October 22, 2015

Subject: Approval, Replacement System Variance Request, Peter & Joanne Foster Property, 562 Island Avenue, Peaks Island, Portland, Maine. Mailing Address Of Owner/Applicant: 35 Howard Street, Portsmouth, NH., 03801.

We have completed our review of an HHE-200 Form dated 05-20-2016 for the property at 562 Island Avenue, Peaks Island, Portland, Maine.

SUBSURFACE WASTEWATER DISPOSAL PLAN

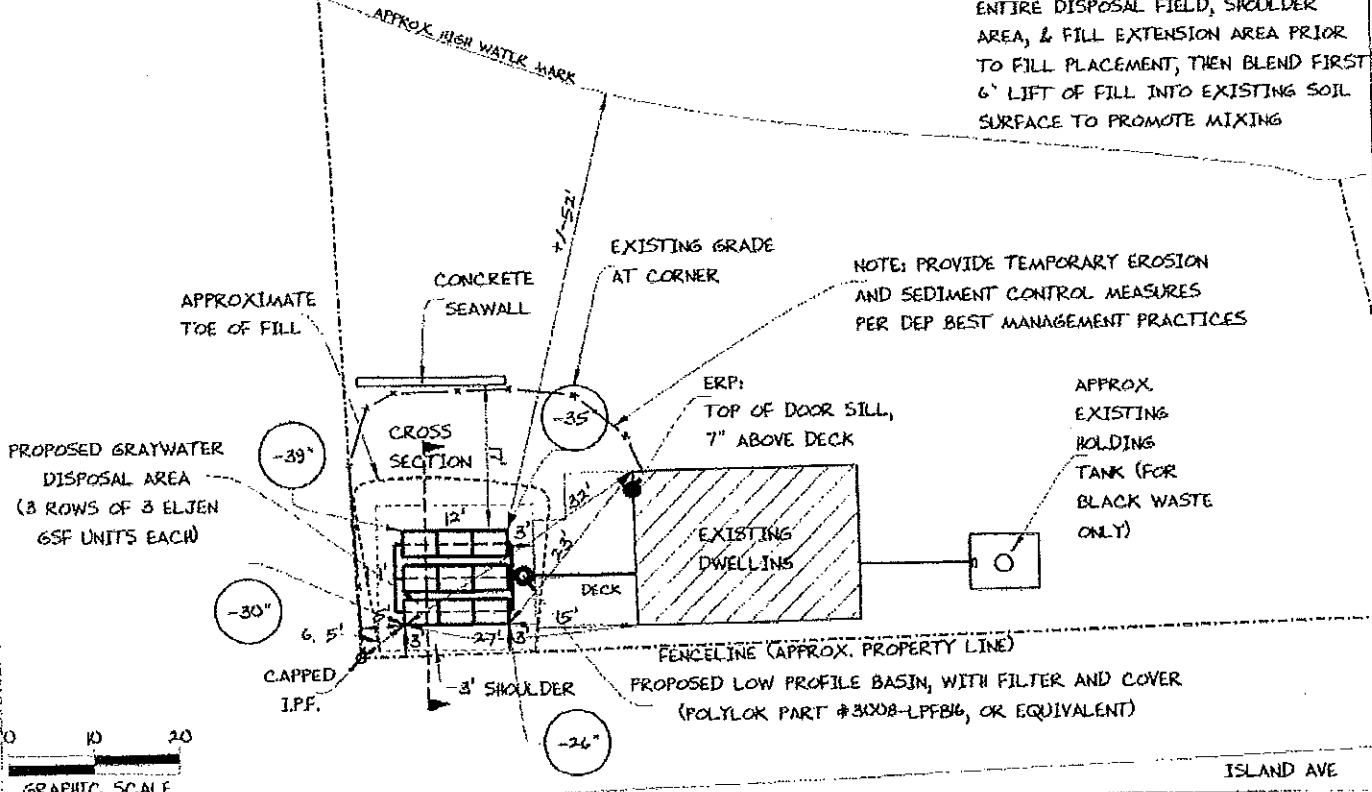
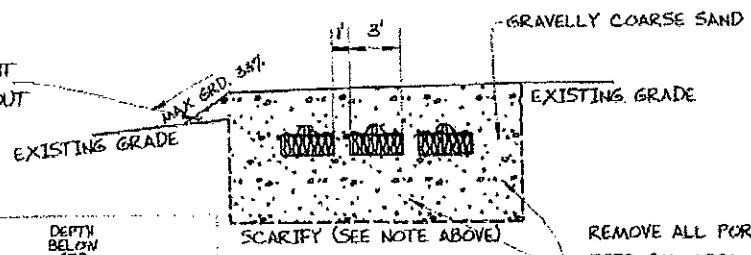
The variance requested which is not within the LPI's authority is from the disposal field to a no full basement of 3 feet and to a property line of 3 feet.

The variances requested that is within the LPI's authority is from the disposal field to major watercourse of 52 feet and 3:1 fill extensions.

The variance request has been submitted because topography and existing development limit the potential of the system location and the system design prepared by Albert Frick SE #163 on 05-20-2016 is otherwise found to be in compliance with the Maine Subsurface Wastewater Disposal Rules.

We approve the local requested variance with the following requirements:

1. A permit for system installation is to be obtained from the Local Plumbing Inspector in advance of the start of system construction.
2. The system is to be installed in accordance with the submitted and approved system design. Should alterations to the design be required at the time of construction, the site evaluator is to be notified prior to making any changes.
3. The contractor is to scarify the soils under the fill extensions to create a transitional zone more compatible with the disposal field area.
